**PERSIMMON HOMES THAMES VALLEY
NORTH LITTLEHAMPTON
LYMINSTER BYPASS (SOUTHERN
SECTION)
LITTLEHAMPTON, WEST SUSSEX**

**STAGE 1 - ROAD SAFETY AUDIT 2ND
ADDENDUM**

FEBRUARY 2018

LYMINSTER BYPASS - SOUTH
NORTH LITTLEHAMPTON
PROPOSED ROAD ALIGNMENT AND
CONTOURS

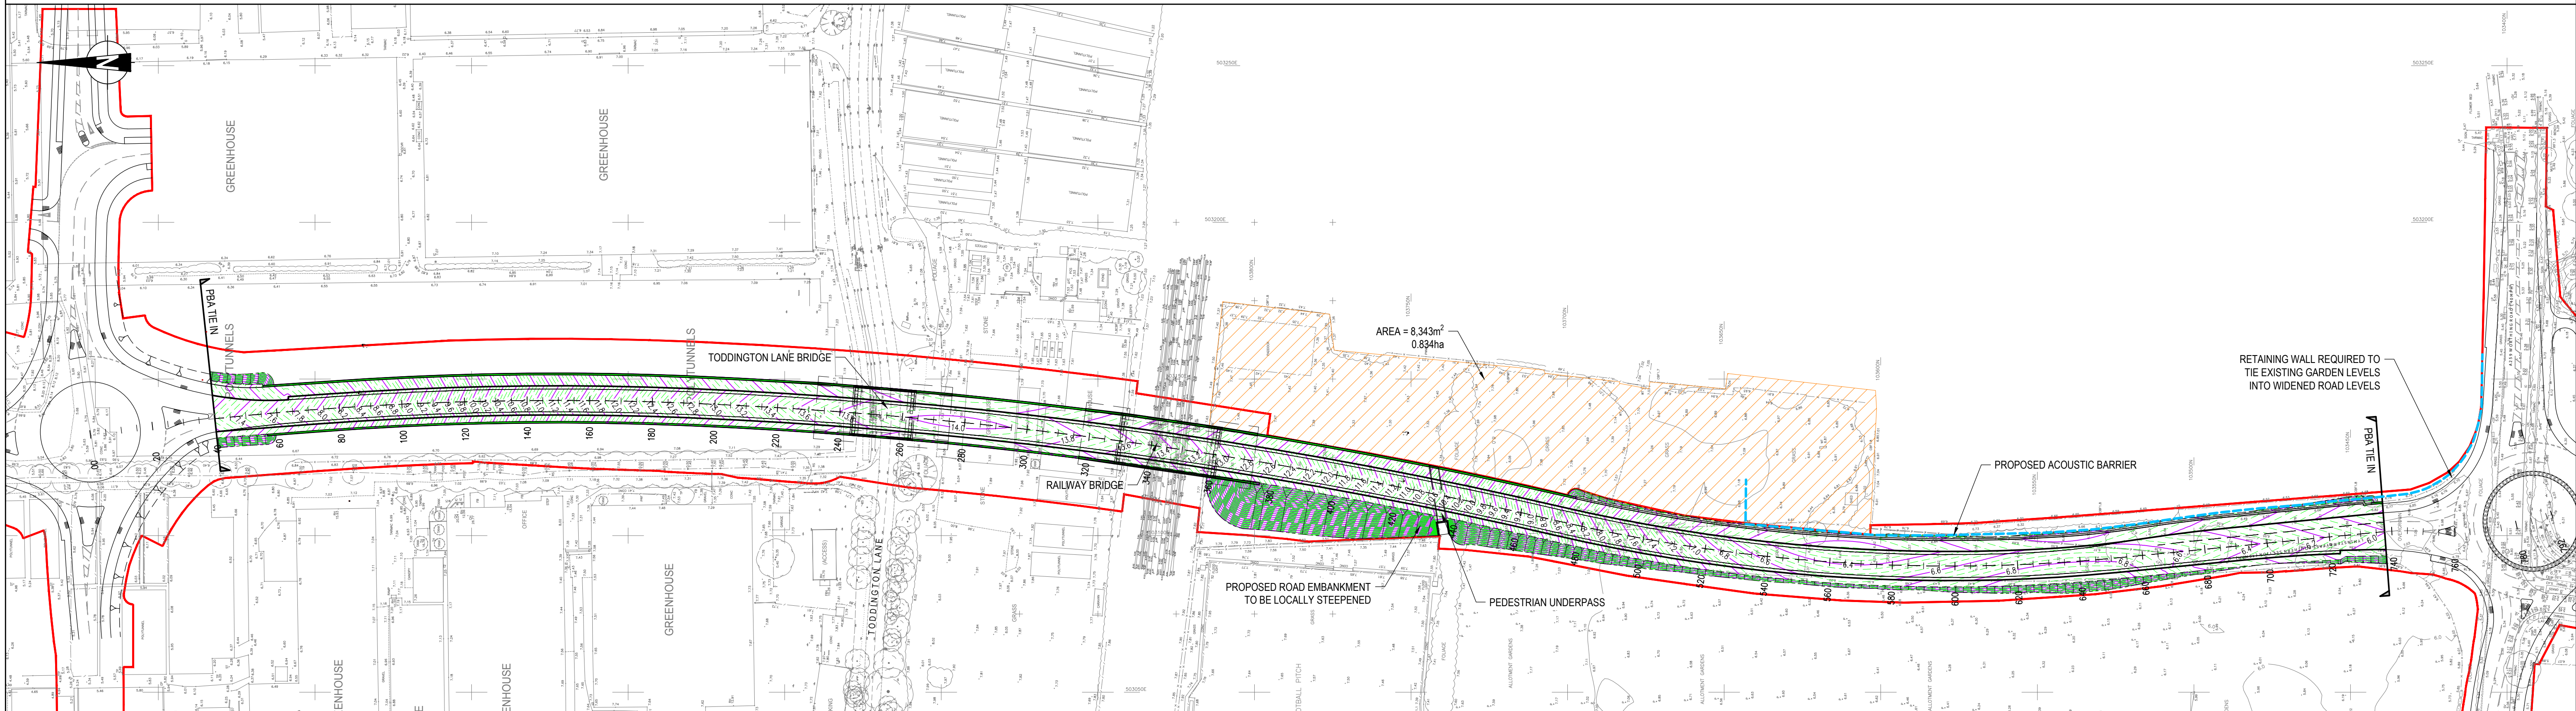
The proposals as shown include a bridge over an existing road and railway.

- i) Provide vehicle restraint barriers and pedestrian fencing as required.
- ii) Ensure that adequate embankment width is provided as required for the provision of barriers or fencing.
